**Re: Objection to MP08\_0244 MOD 1 Modification Request for Mixed Used Development at 23-37 Lindfield Avenue and 11 Havilah Lane, Lindfield**

ELEVATIONS

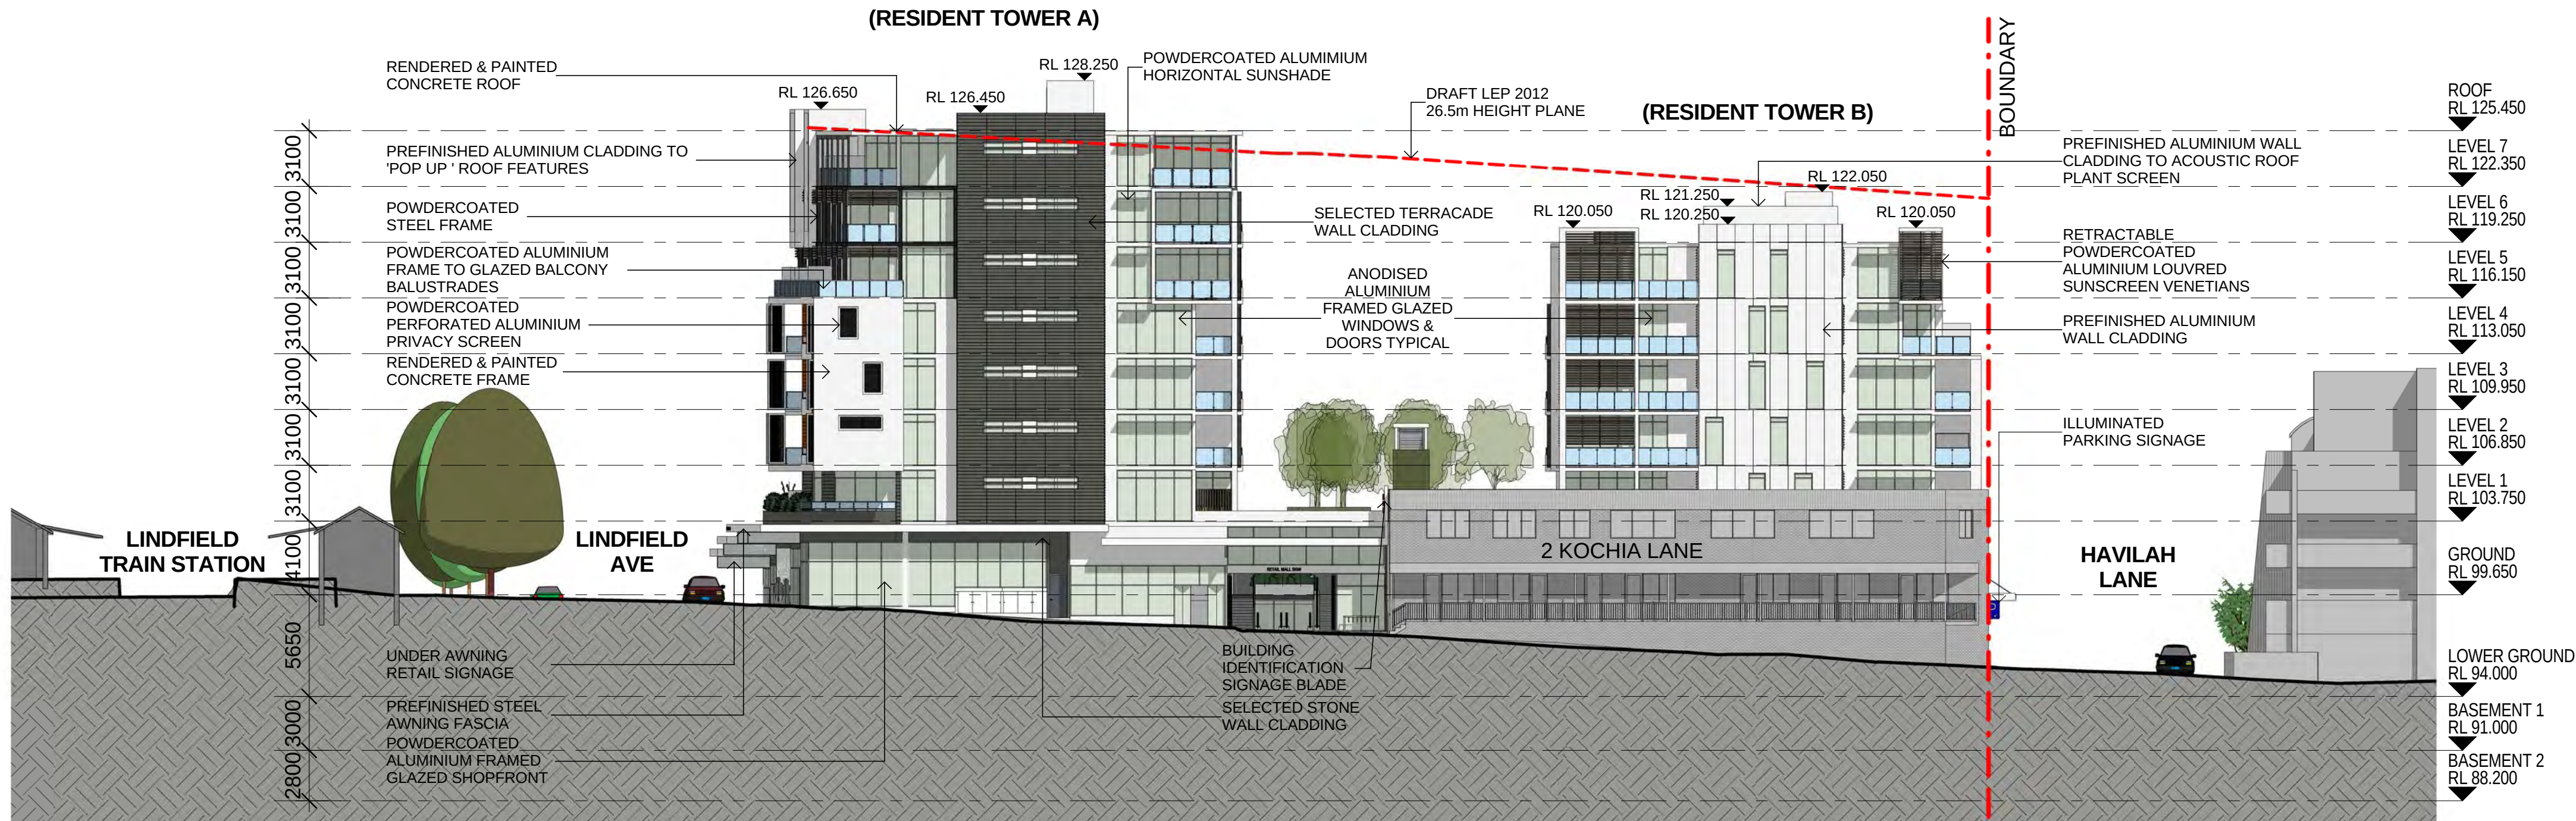
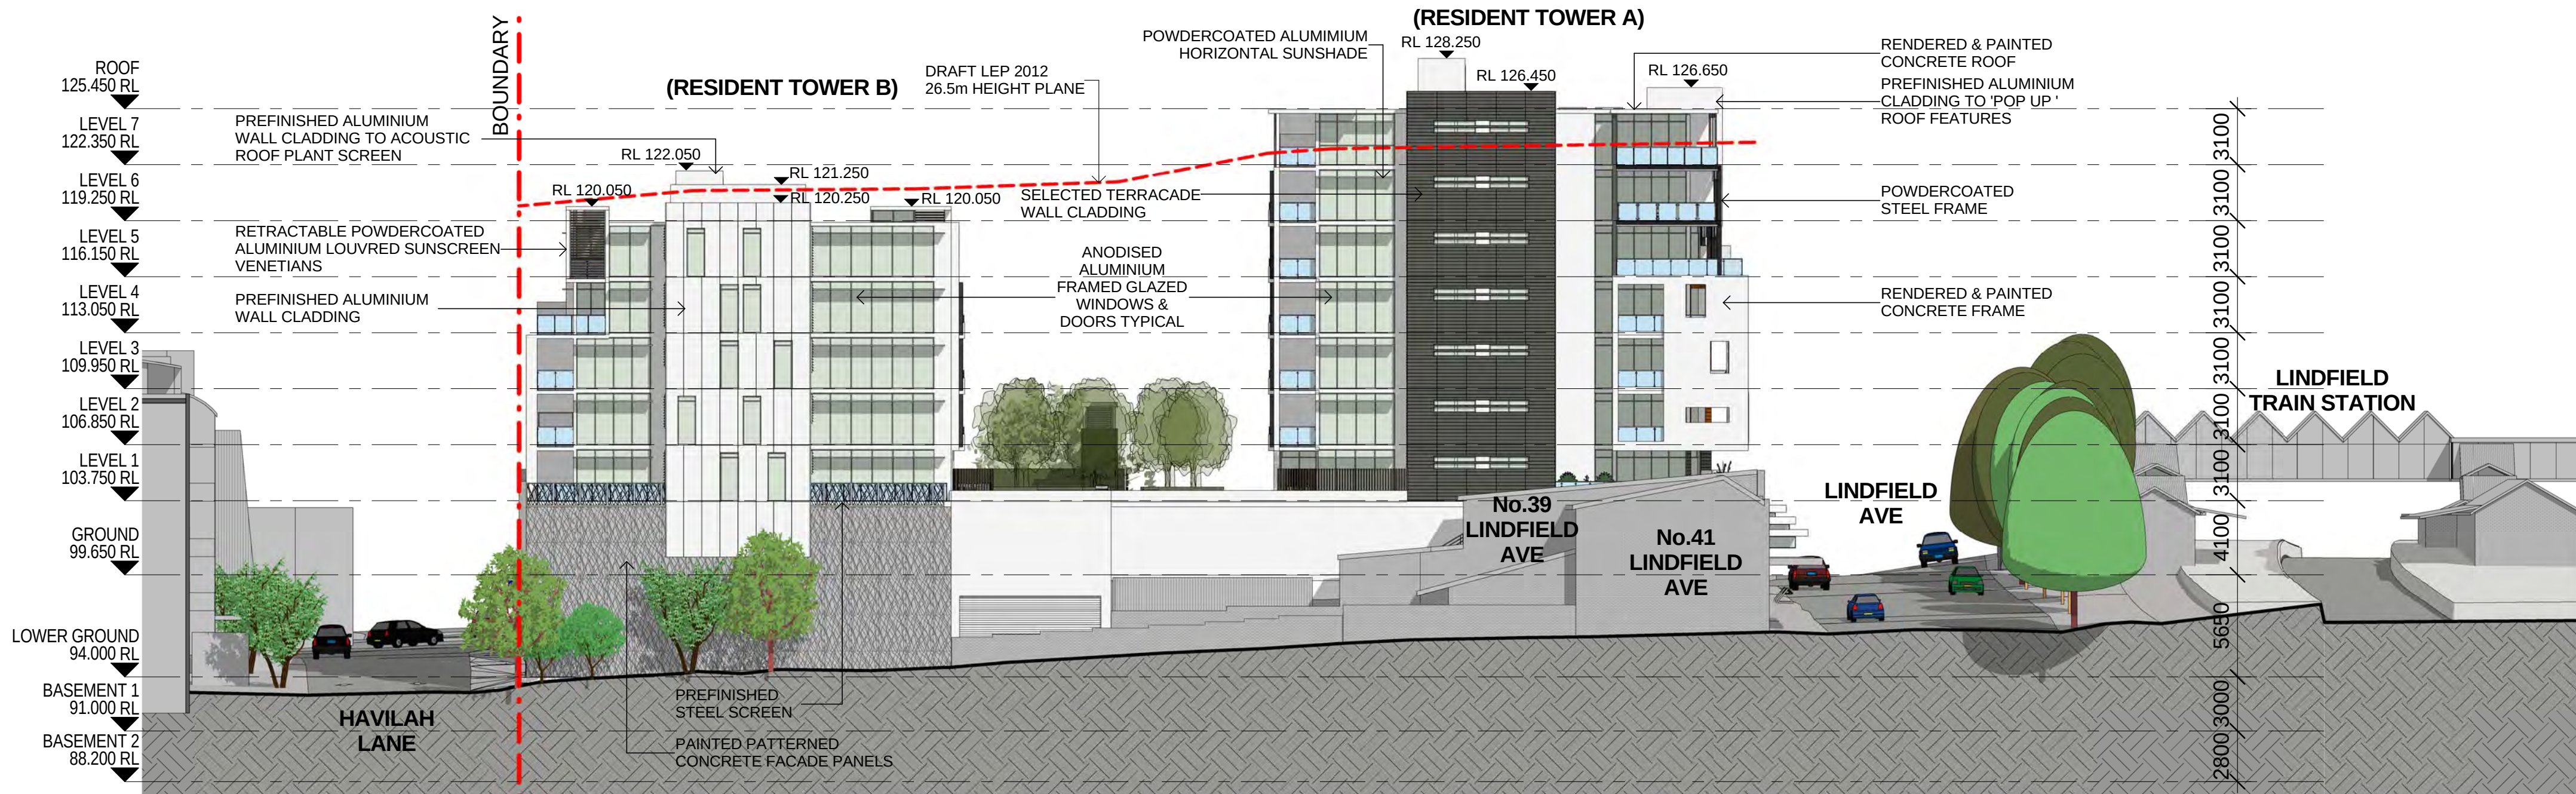
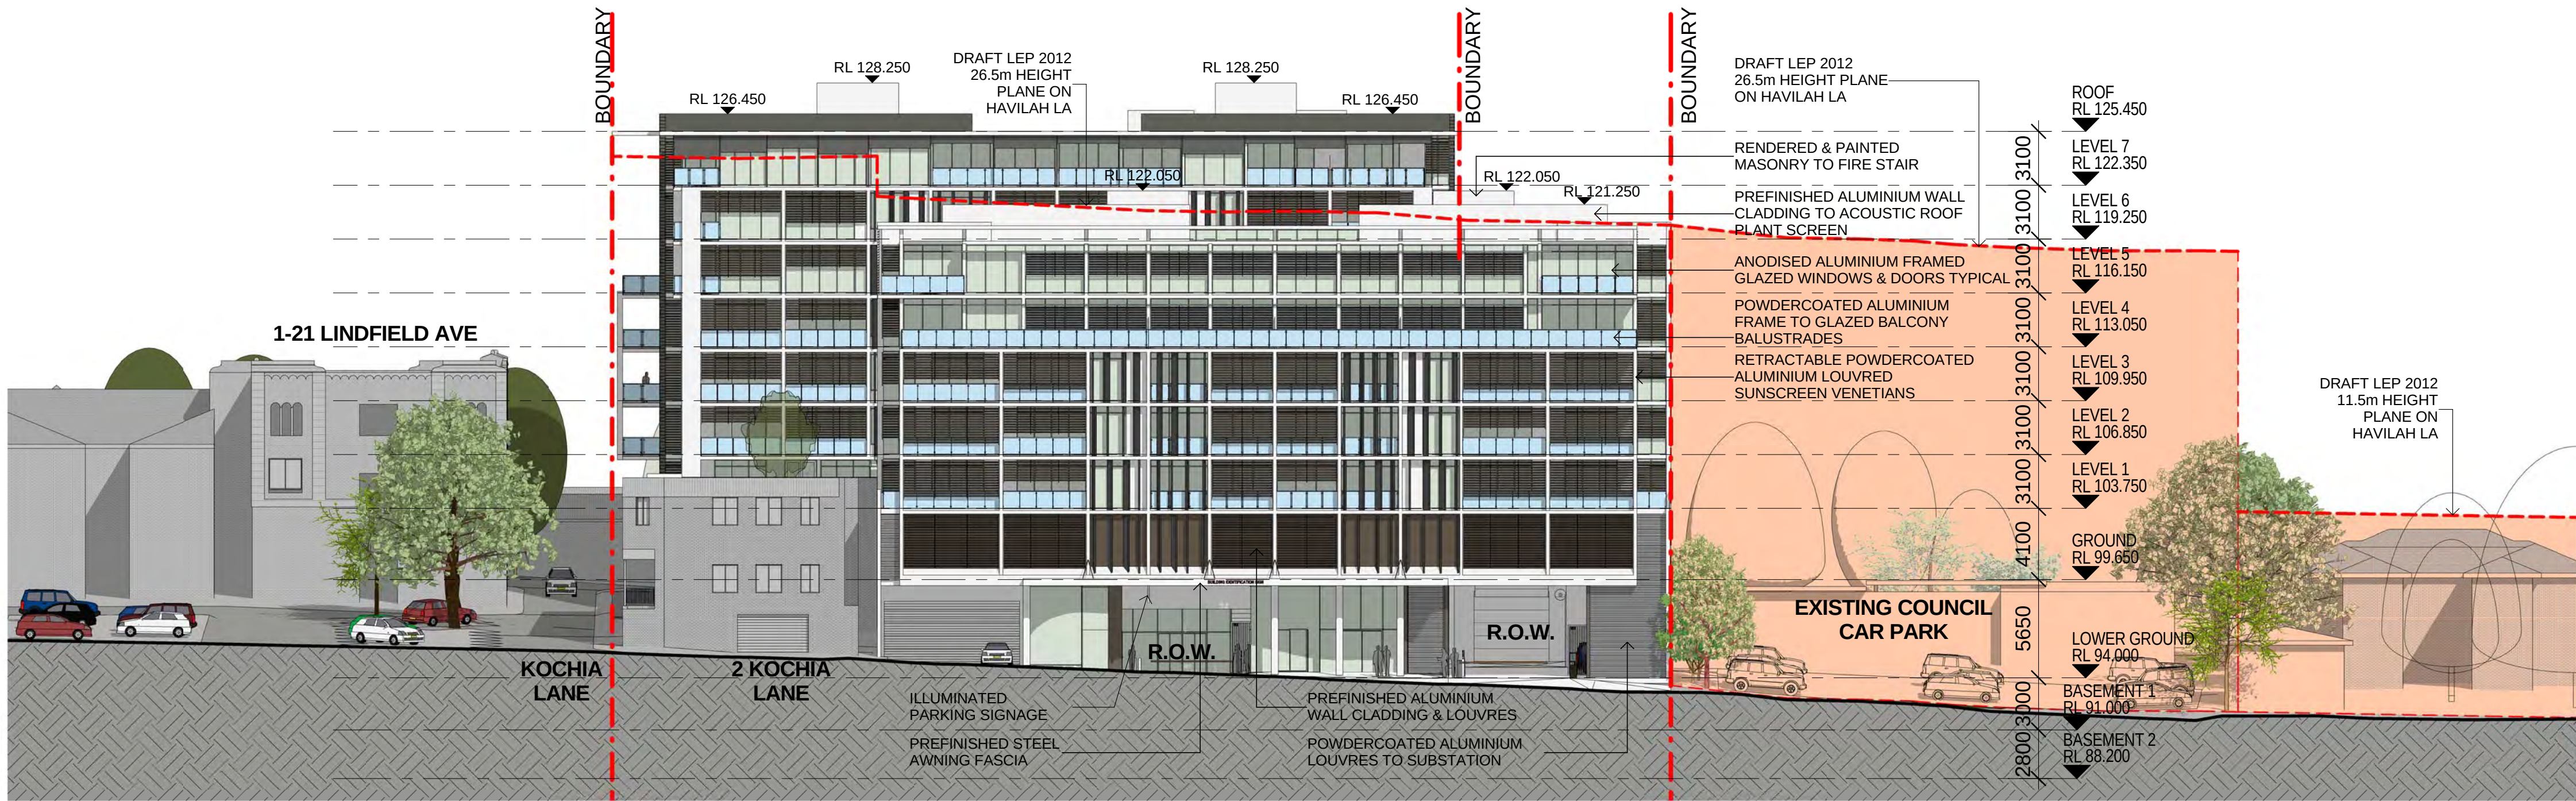
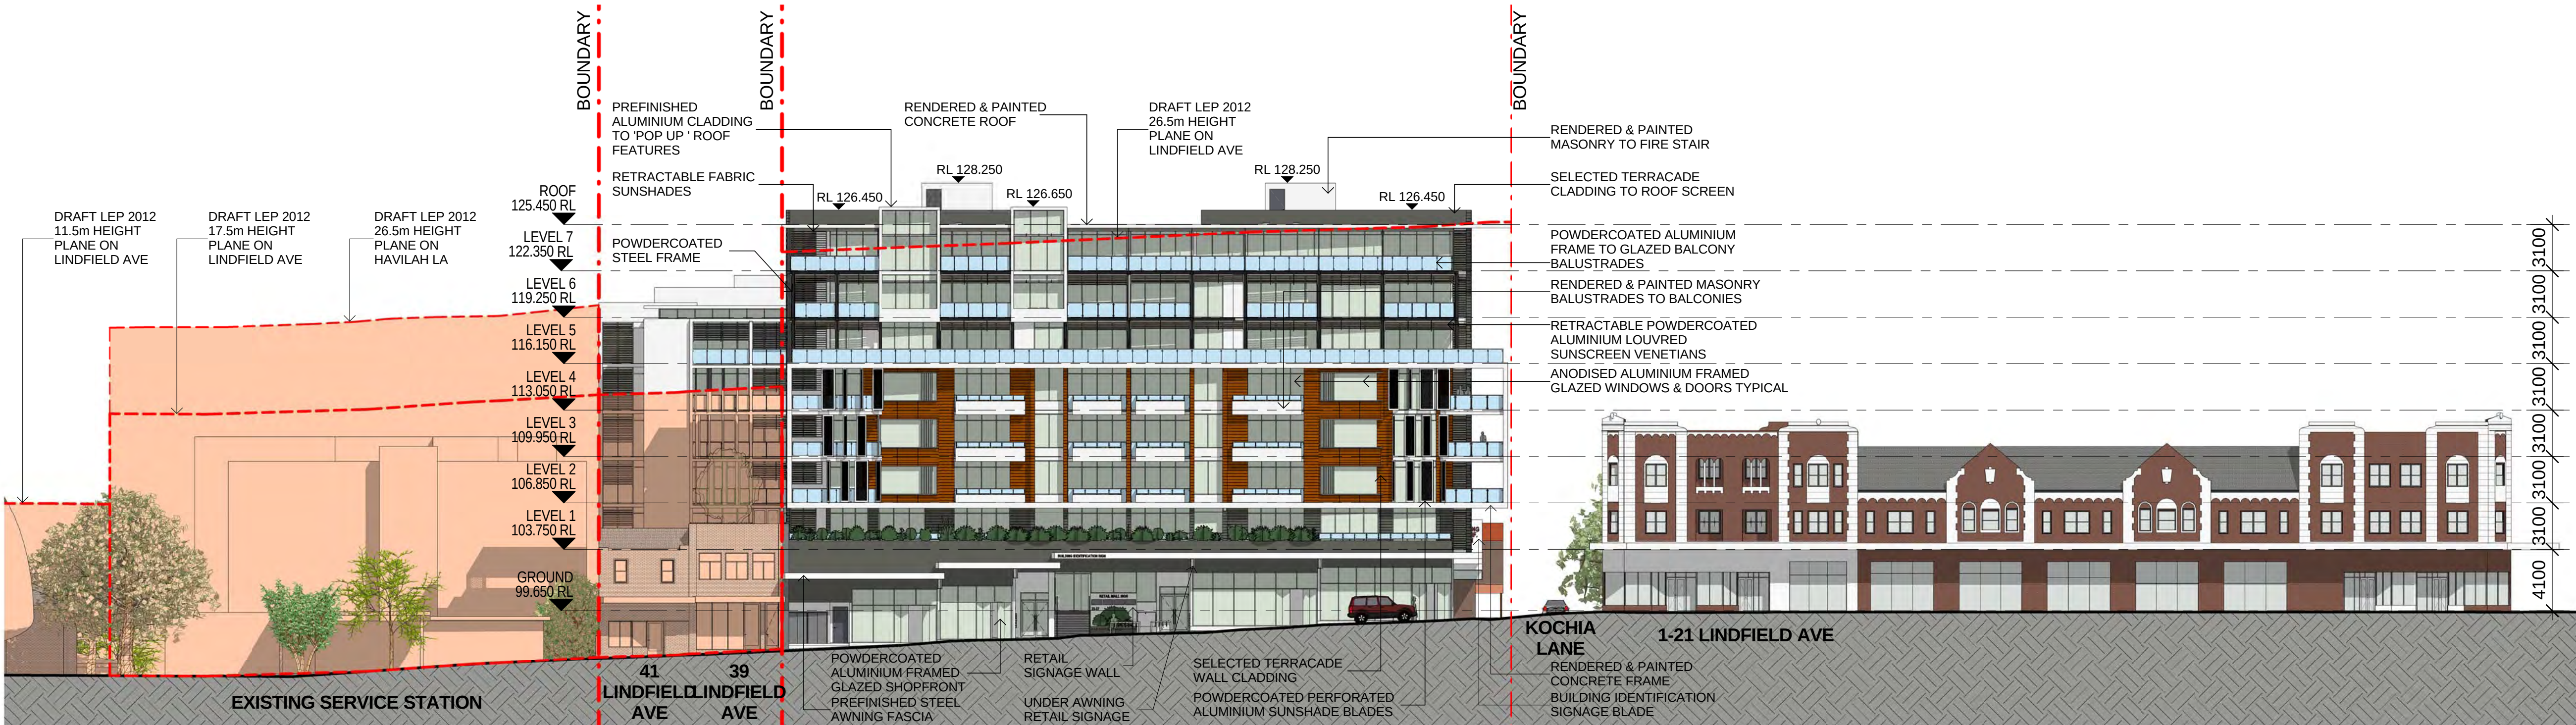
- The increase of an additional storey to both buildings: 8 storeys on Lindfield Avenue and 7 storeys on Havilah Lane creates excessive height and bulk and is out of character with the surrounding buildings, including the heritage listed adjacent building on Lindfield Avenue

- The additional storey (combined with less set back than the approved design) on Havilah Lane now creates privacy concerns for over 40 apartments in the adjacent 8 Havilah Lane, 8 Kochia Lane and 2-8 Milray Street residences
